**WELWYN HATFIELD BOROUGH COUNCIL
EXECUTIVE DIRECTOR - PLANNING, PUBLIC PROTECTION AND GOVERNANCE**

DELEGATED APPLICATION

Application No: 6/2022/0477/HOUSE
Location: 21 Kingswell Ride Cuffley Potters Bar EN6 4LH
Proposal: Alterations to fenestration, part conversion of front hipped roof to gable roof, erection of rear roof extension with conversion of rear hipped roof to gable and insertion of two side dormers.
Officer: Ms Kirsty Shirley

Recommendation: Granted

Drawing title  
Proposed Elevations

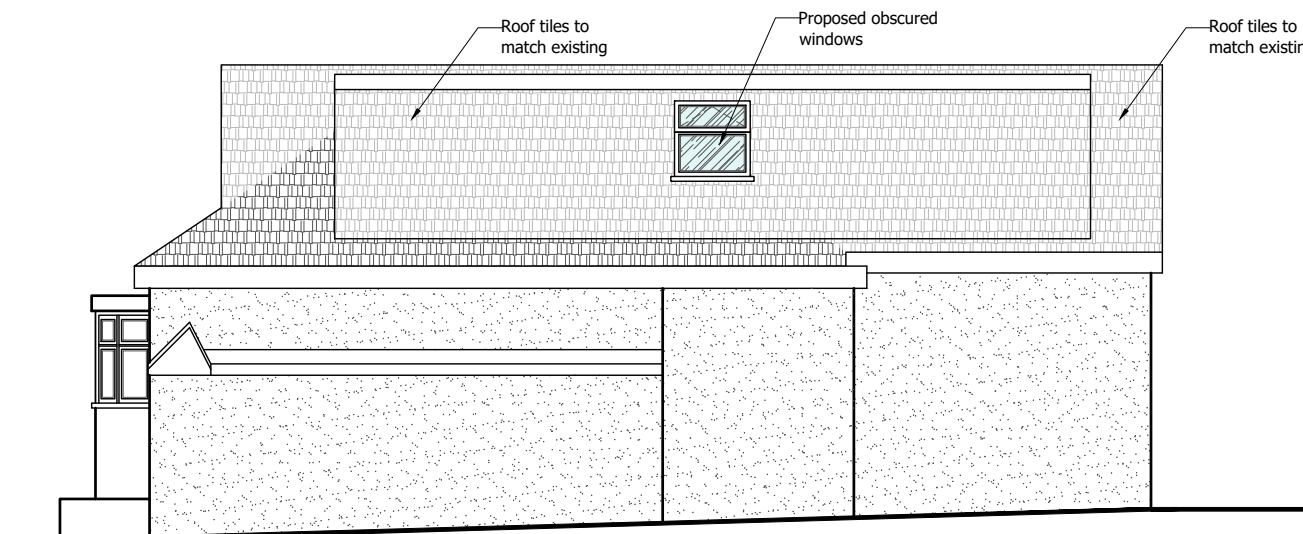
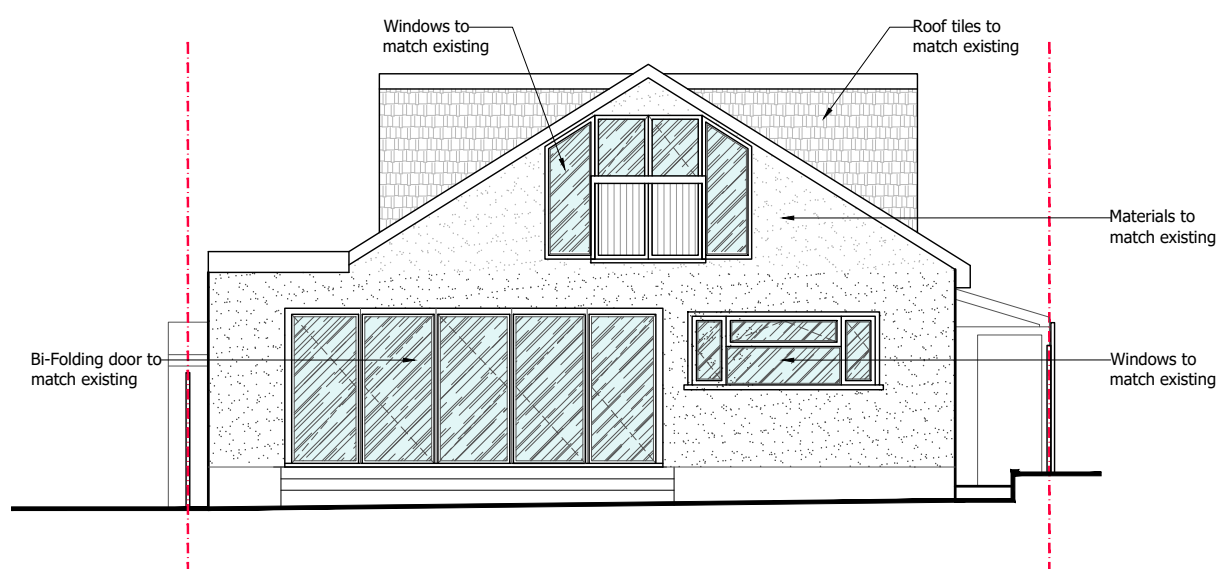
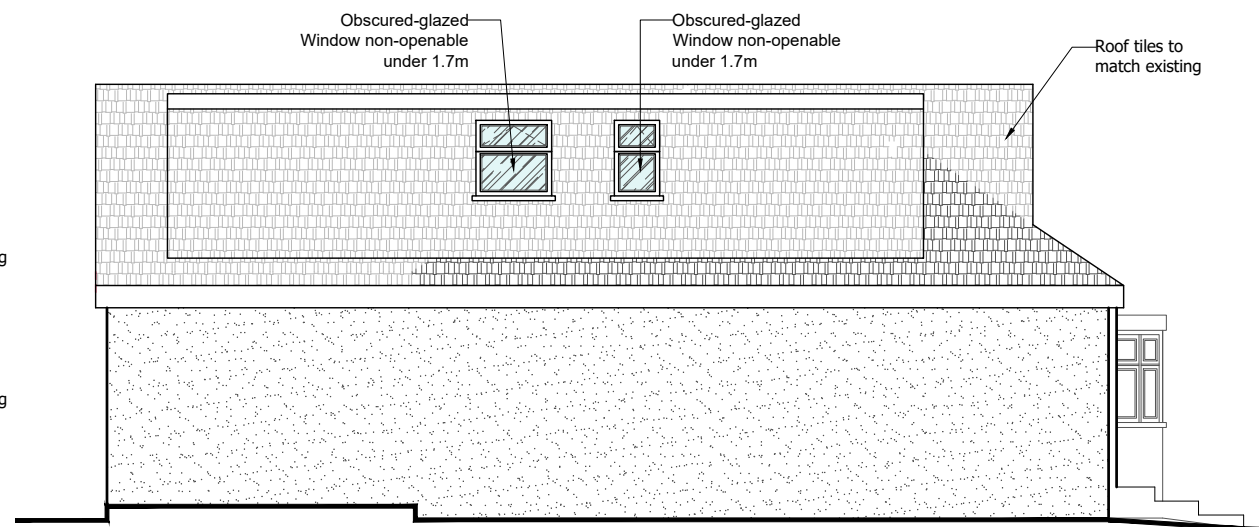
Two sizeable flat roof dormer windows are proposed on the resultant side of either side of the roofslope. Large flat roof dormers are a feature of many dwellings in the area and therefore represent an acceptable form of development in this location. The dormers would be contained within the roof slope, set down from the ridge and would ensure a 1m set in from each flank elevation. The fenestration would also be in proportion to the fenestration of the dwelling. The proposed dormers are considered to comply with the Council's SDG.

Regarding privacy, the windows inserted into the side elevations of the dormers would be obscured glazed and non-opening under 1.7m, and this can be secured by condition to ensure the privacy of adjoining neighbours Nos 19 and 23 is maintained.

2. The windows inserted into the side elevations of the dormer windows facing towards adjoining neighbours Nos 23 and 19 hereby approved must be obscure-glazed and non-opening unless the parts of the window which can be opened are more than 1.7 metres above the floor of the room in which the window is installed, and shall be retained in that form thereafter.
